2024/0442

Address: 22 Manor Crescent, Grimethorpe, Barnsley, S72 7AF

Description: Removal of chimney and installation of dormer to 2 storey semi-detached dwelling

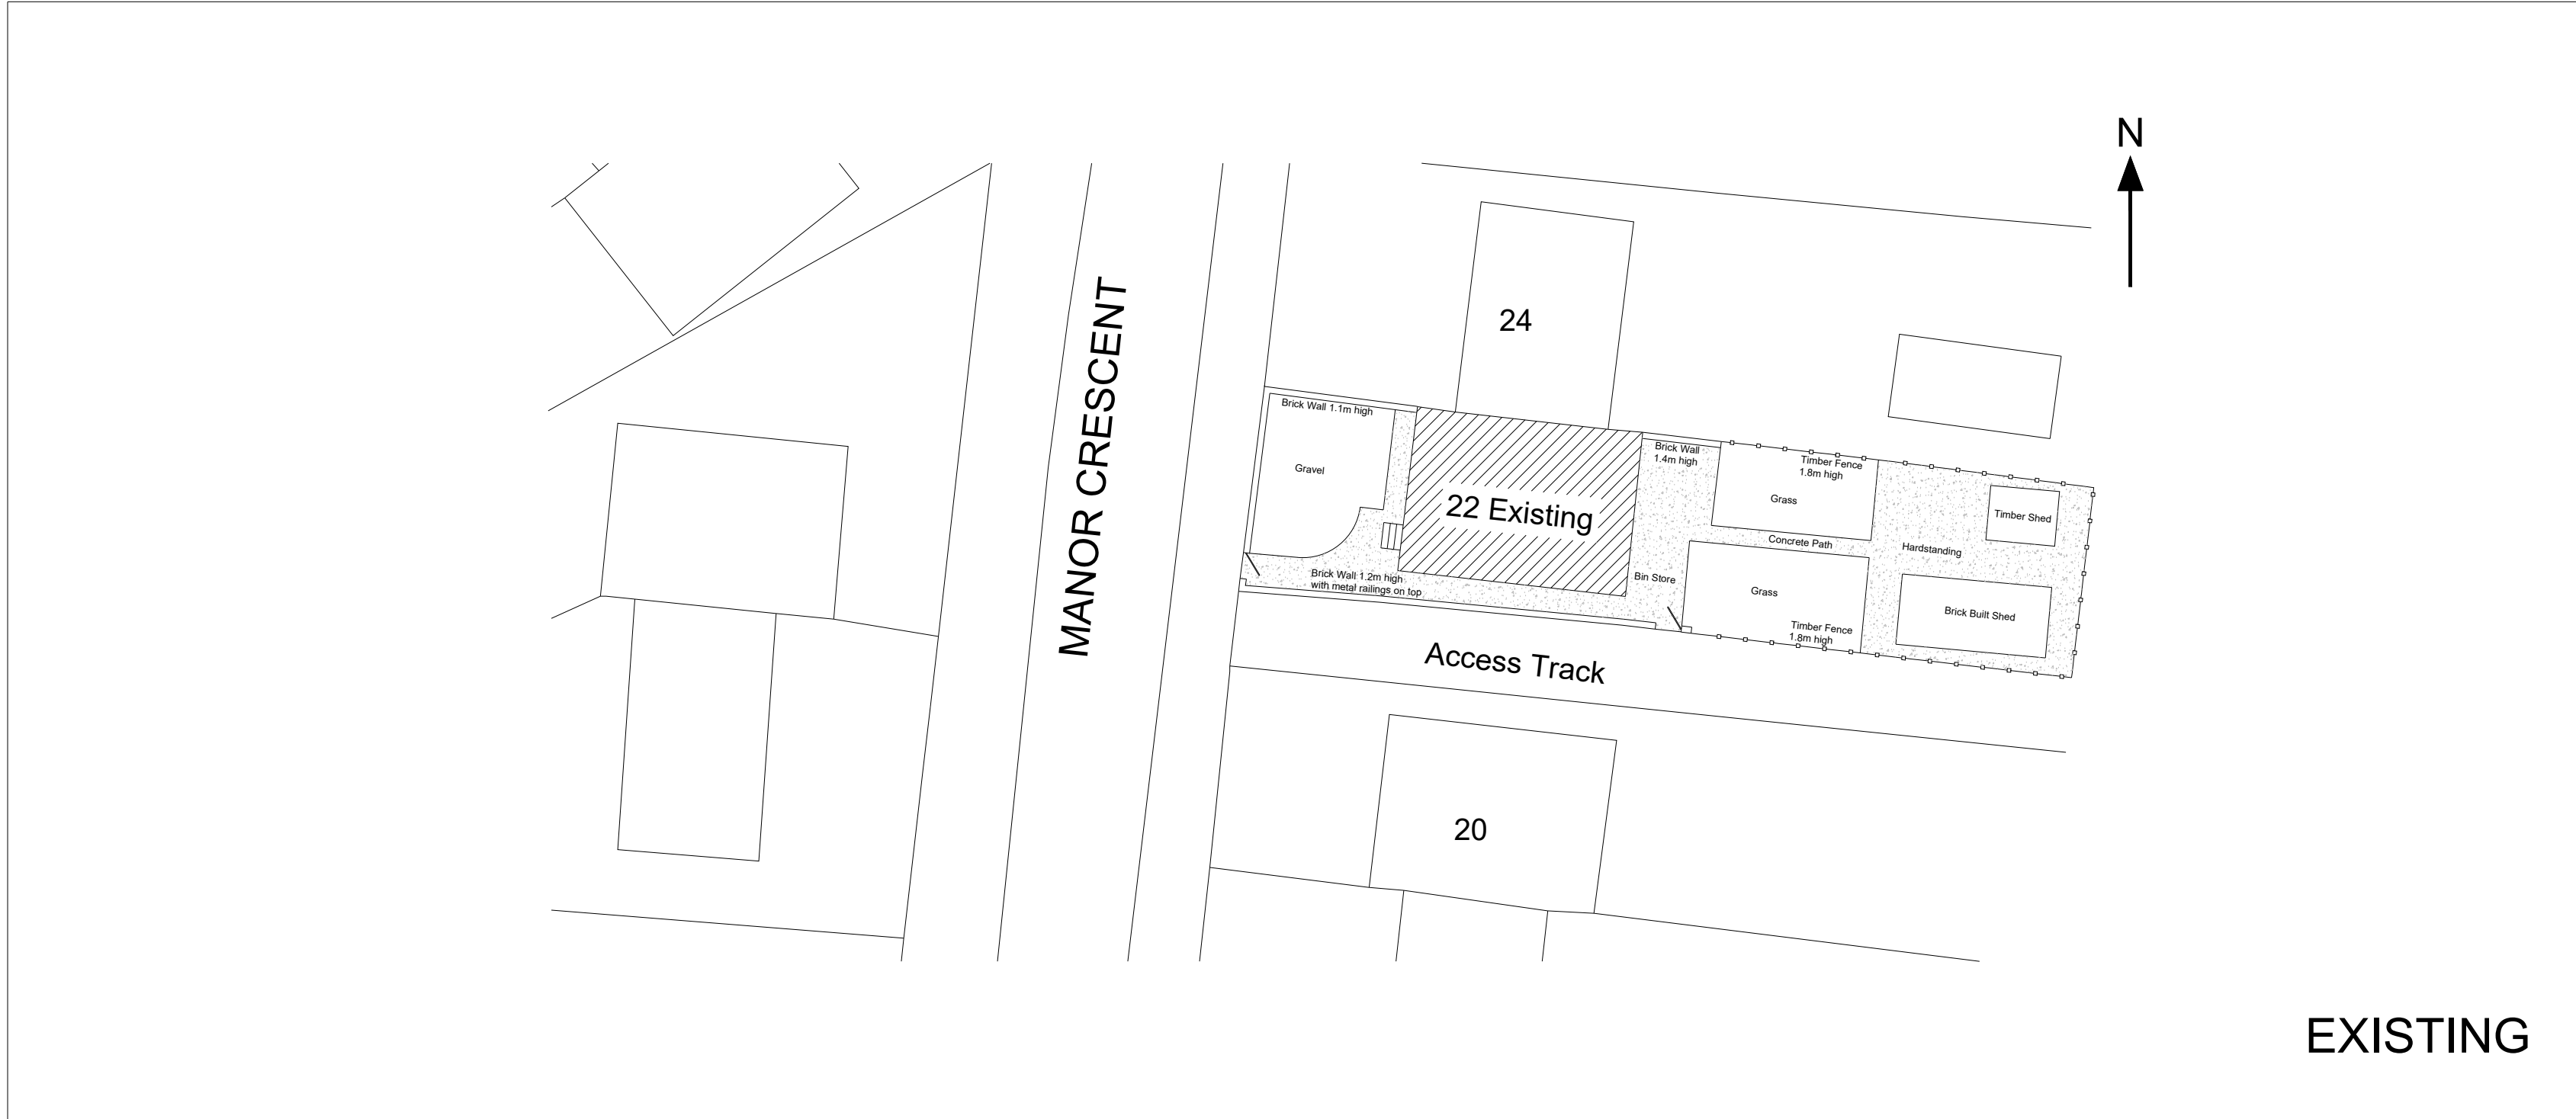
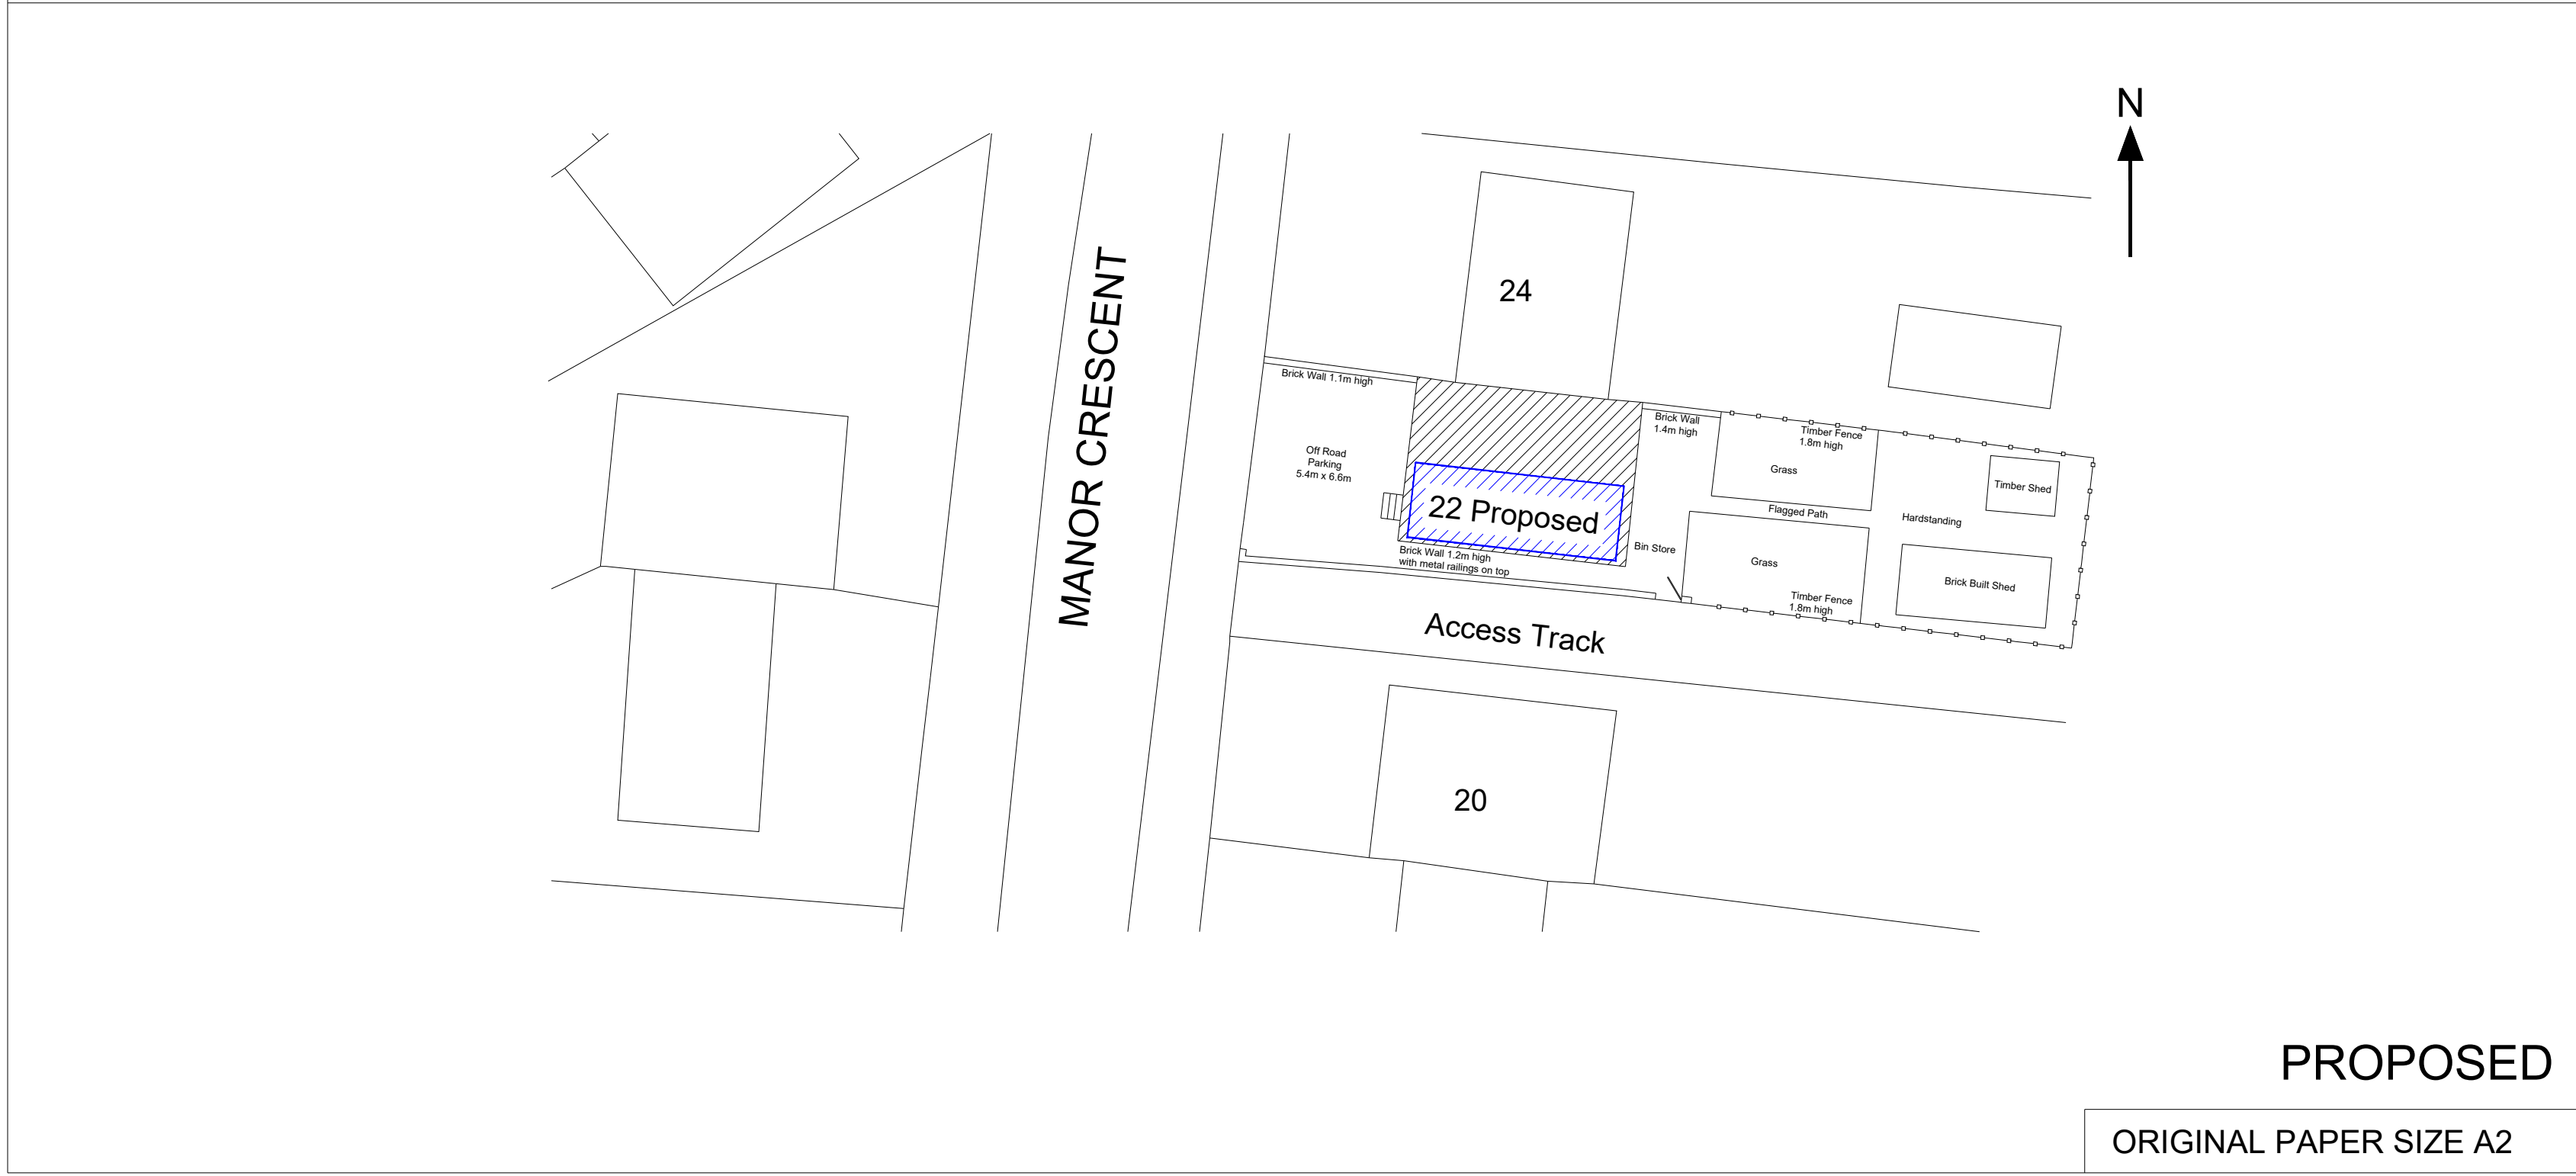
Highways DC: With an increase in the number of bedrooms, Highways did not consider the existing semi-formal parking provision within the front garden as adequate. Revised plans were submitted with amendments to the existing parking provision. Upon assessment of the plans, Highways withdrew their objection subject to a standard condition in relation to the standard of parking provision provided.

Following highway advice and with provided conditions, there are proposed changes to the parking provision, but these would improve both parking and highway safety, in relation to the application dwelling and access into and out of the cartilage.

SIDE ELEVATION FROM NO 24 - PROPOSED

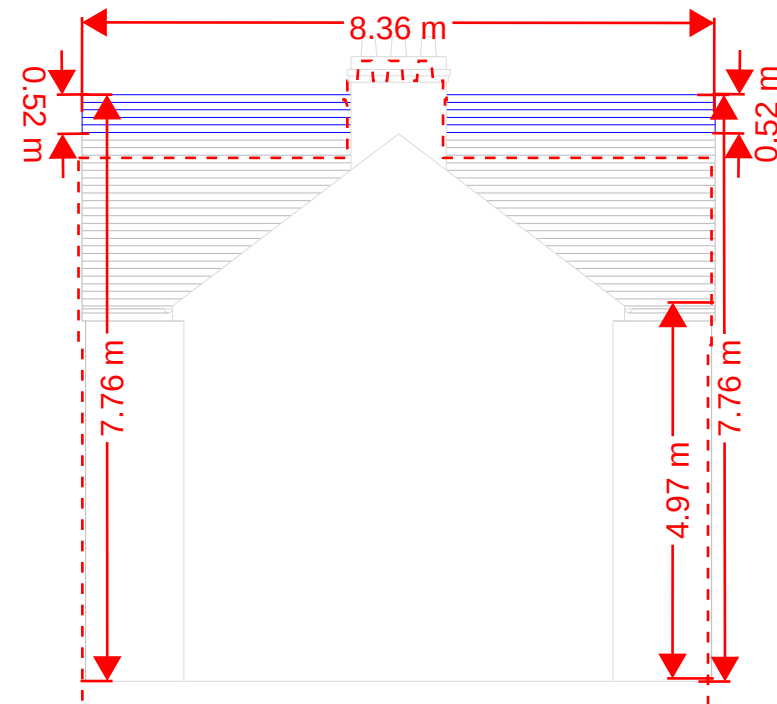
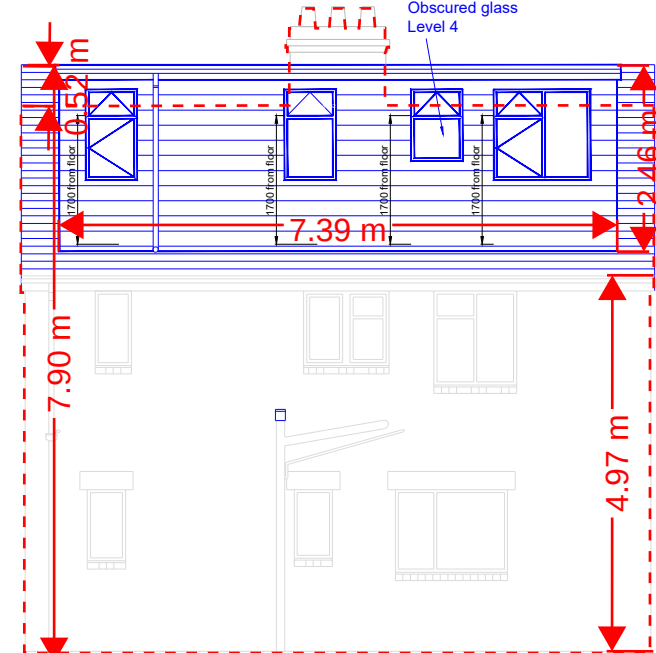
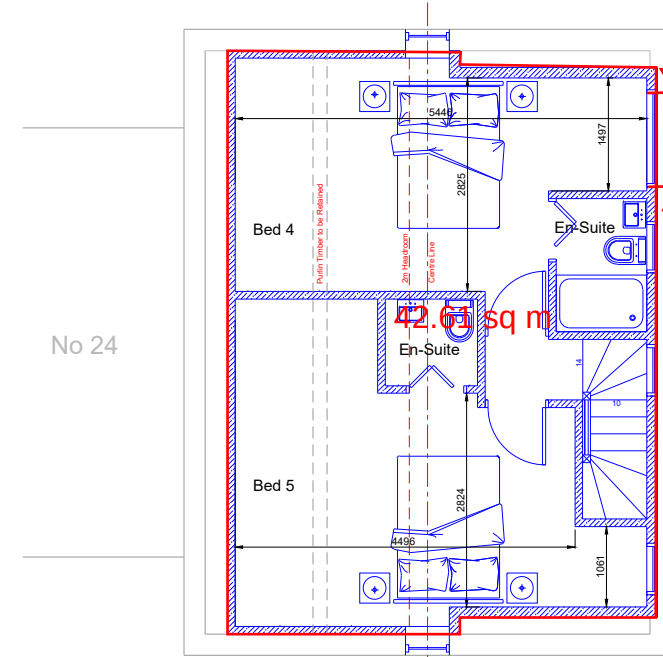
The proposal had been amended from that which was originally proposed, and whilst some concern remains over impact of residential amenity on the neighbouring dwelling of No.20, concern over the residential amenity of the current and potential future users of the dwelling has been modestly improved through the enlargement of new windows on the front and rear elevation of the dwelling. The impact of overbearing on the adjacent neighbouring dwelling of No.20 has hopefully been reduced by a reduction in the proposed increase of roof height, dropping from 7.91m to 7.76m, an

increase in current roof height of 50cm, instead of 65cm, whilst still maintaining a 2m clearance (where appropriate) within the rooms inside the roof space. There remains some concern of overlooking on No.20 by the proposed dormer extension but it would appear the windows would predominantly overlook the roofline of No.20 or secondary non-habitable windows. The exception would be the proposed dormer window at the rear of the side elevation. This window may potentially overlook into the bedroom on the opposite elevation of No.20, which is set considerably lower. It would though not be suitable to request obscure glazing, as is found in the proposed adjacent bathroom window, as that could be restrictive on the amenity of the users of the dormer. In mitigation of the concern, it appears that the existing first floor bedroom windows (as with other windows) on the side elevations of both dwellings would already overlook each other. With an approximate 5.19m distance between the elevations, it would be assumed that if the mutual overlooking of any dwelling was a concern, it would already be mitigated against by the relevant occupiers, and that the potential caused by the window in the dormer would be much less significant.

For the residential amenity of the loft conversion and dormer, unlike an existing bedroom, on the first floor, which may have been deemed too small by current spacing standards; the rooms within the loft are of an acceptable size. Whilst the dormer windows may provide a prominent view across the roof lines of neighbouring dwellings, the increased size of the still modest sized windows on the front and rear elevations would provide better outlook without harming the amenity of neighbouring dwellings. Although the distance between the proposed front window and the dwelling across the street is just under 20m this would be the same distance as existing windows on the application dwelling, and between comparable dwellings on the street. The rear window looks over informal green space to the rear of the dwelling.

FRONT ELEVATION - PROPOSED

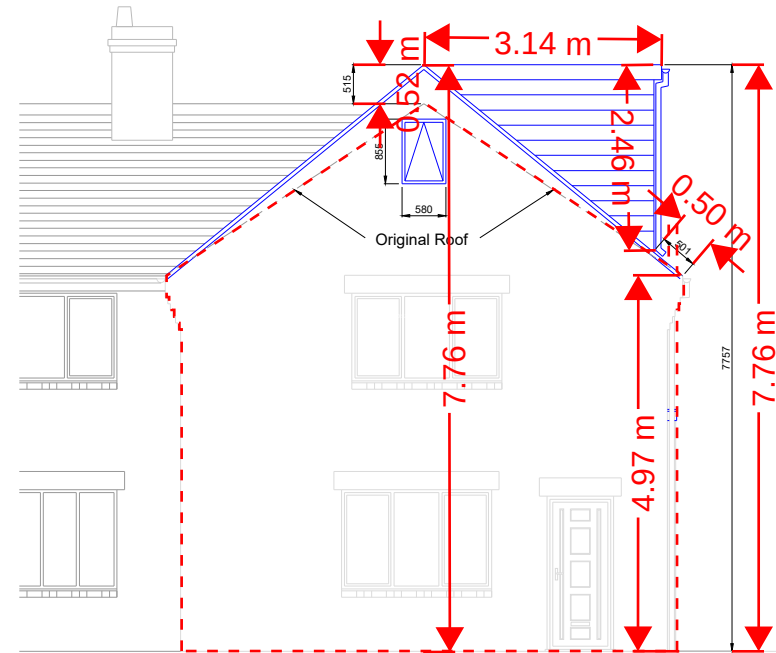
There will be some impact on the character of the dwelling, and upon the street scene caused by the proposed dormer. Whilst its position on the side of the dwelling is more preferable than being located on the front elevation, a dormer on rear elevation may have reduced the impact on the principle front street scene further. The initial plans included a larger increase to the existing ridge height of the house, but with the adjacent dwelling set lower, would have been a significant disparity. The ridge height has now been reduced by 15cm, and the dormer is inline within this ridge, whilst still increasing the roof height, the impact within the street scene would be reduced. If the roof height had not been increased, the size and location of the dormer would have been allowable through permitted development rights. Within the broader street scene, unlike a rear or front dormer, the dormer would be reasonably hidden from view, when looking at a broad view of the street scene but would become more visible within close proximity to application dwelling. Overall, it would appear that the impact of the dormer would be noticeable but would only have a small impact on the dwelling and street scene, it would be not be considered significant enough to merit a refusal of the application.
